**KIRKLEES METROPOLITAN COUNCIL
INVESTMENT & REGENERATION SERVICE**

DELEGATED DECISION TO DETERMINE PLANNING APPLICATIONS

Reference No:	2023/62/90082/W
Site Address:	1, Yew Tree Gardens, Birchencliffe, Huddersfield, HD3 3ZS
Description:	Erection of first floor side extension
Recommending Officer:	Teresa Harlow

OFFICER REPORT

Proposed Side Elevation

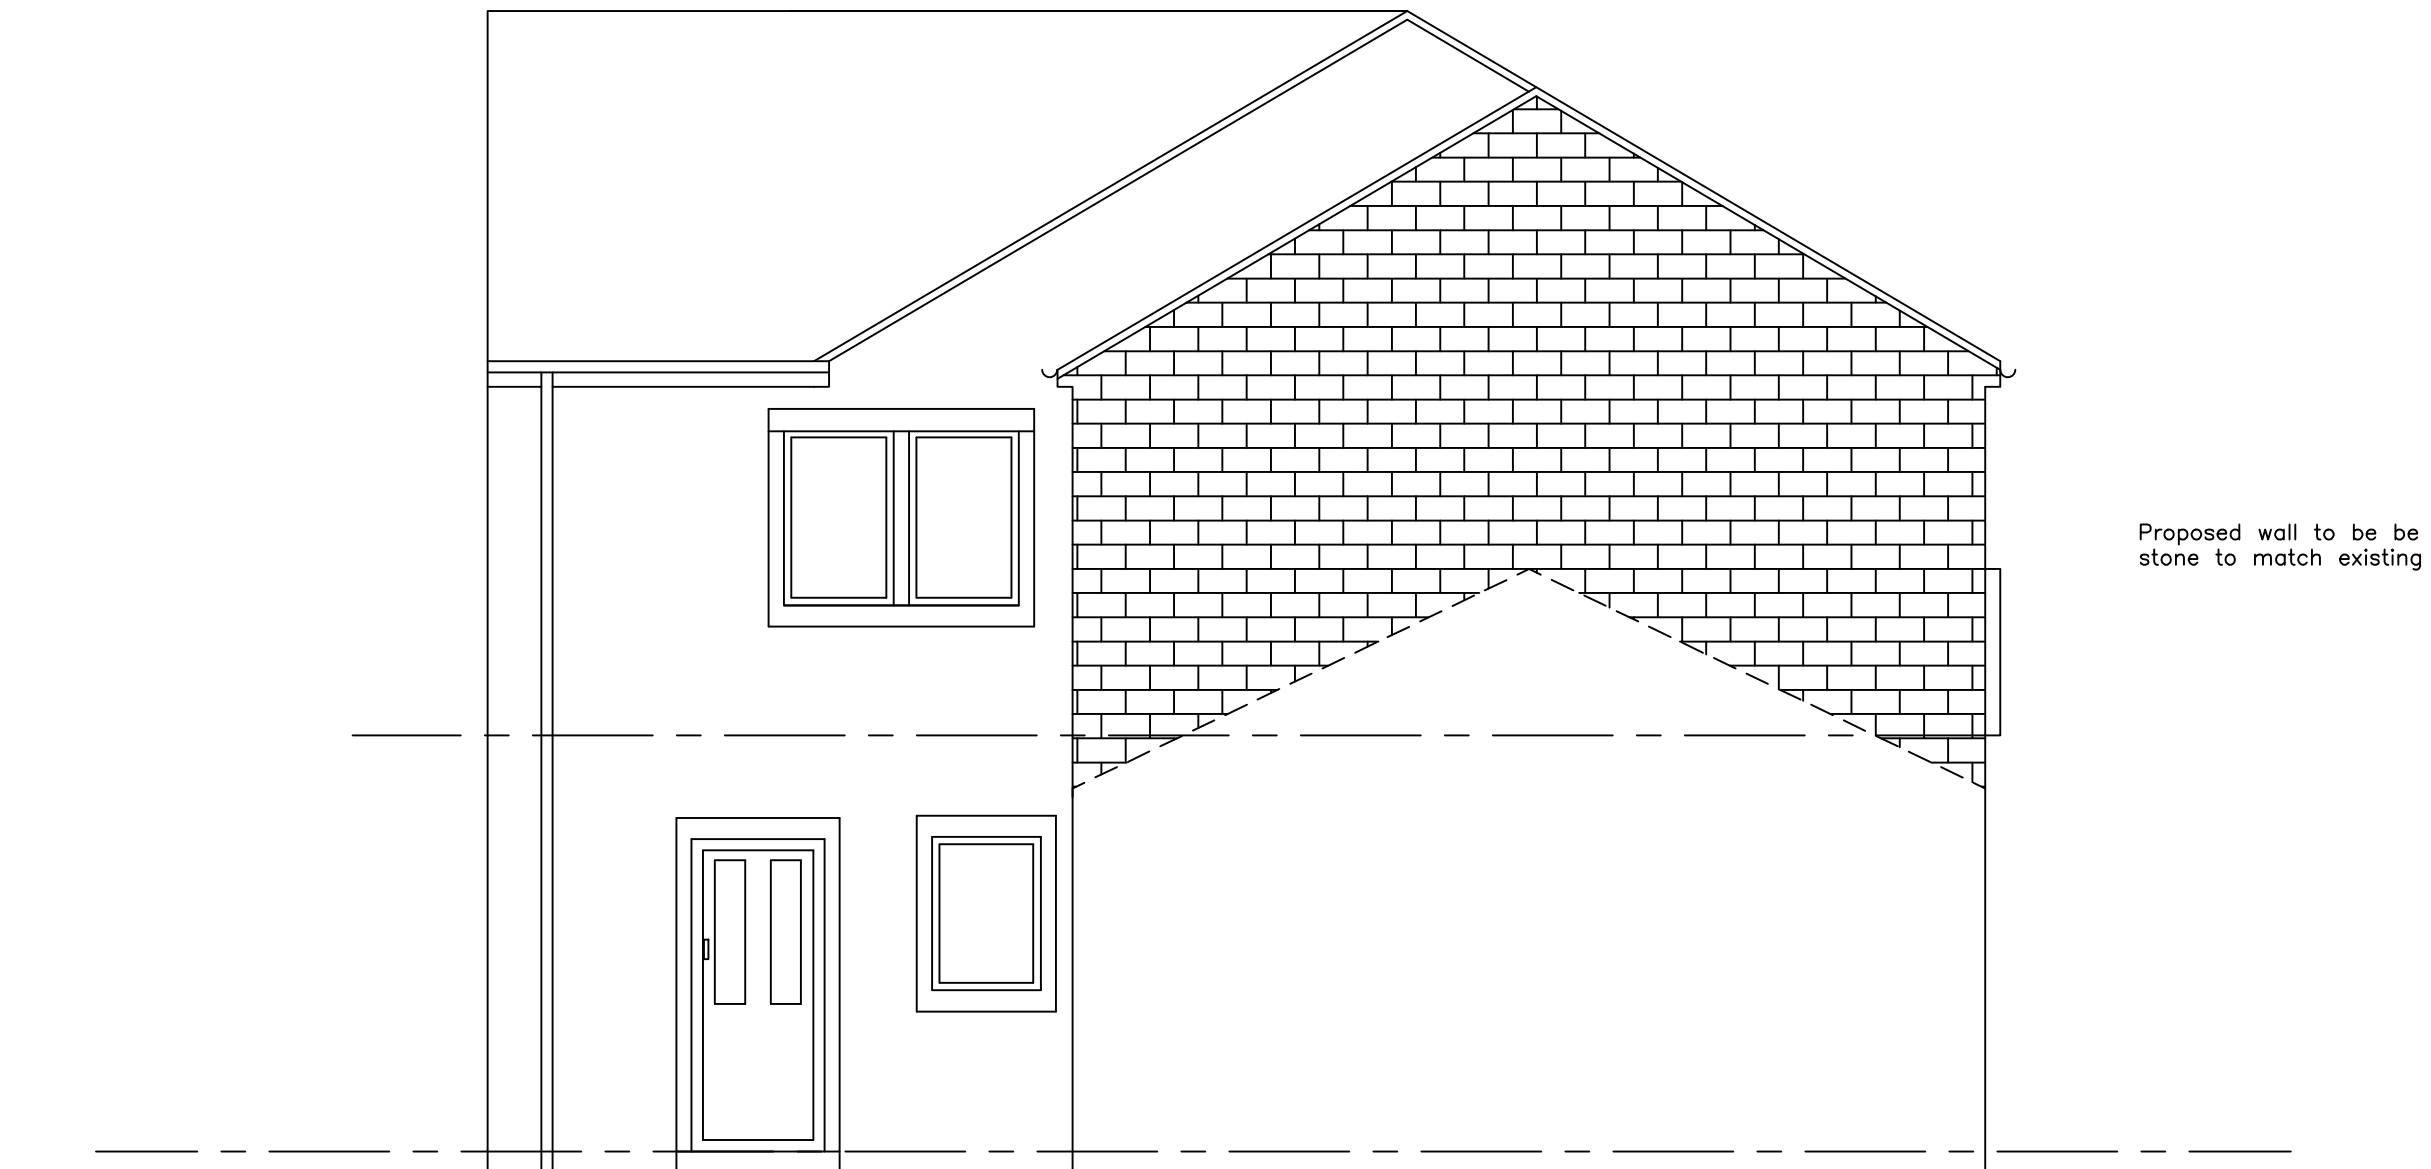
The proposal sits ~7.0 m from the shared boundary with no. 64 Yew Tree Road, on the west. There would be no windows in the gable elevation, and new opening here would be prevented by condition on the 2013 permission and the requirements of the GPDO. Given the separation distance, scale of the development and its layout, it is concluded that this would not adversely impact on 64 Yew Tree Road or its rear amenity space in terms of overlooking, loss of outlook, loss of light or overshadowing
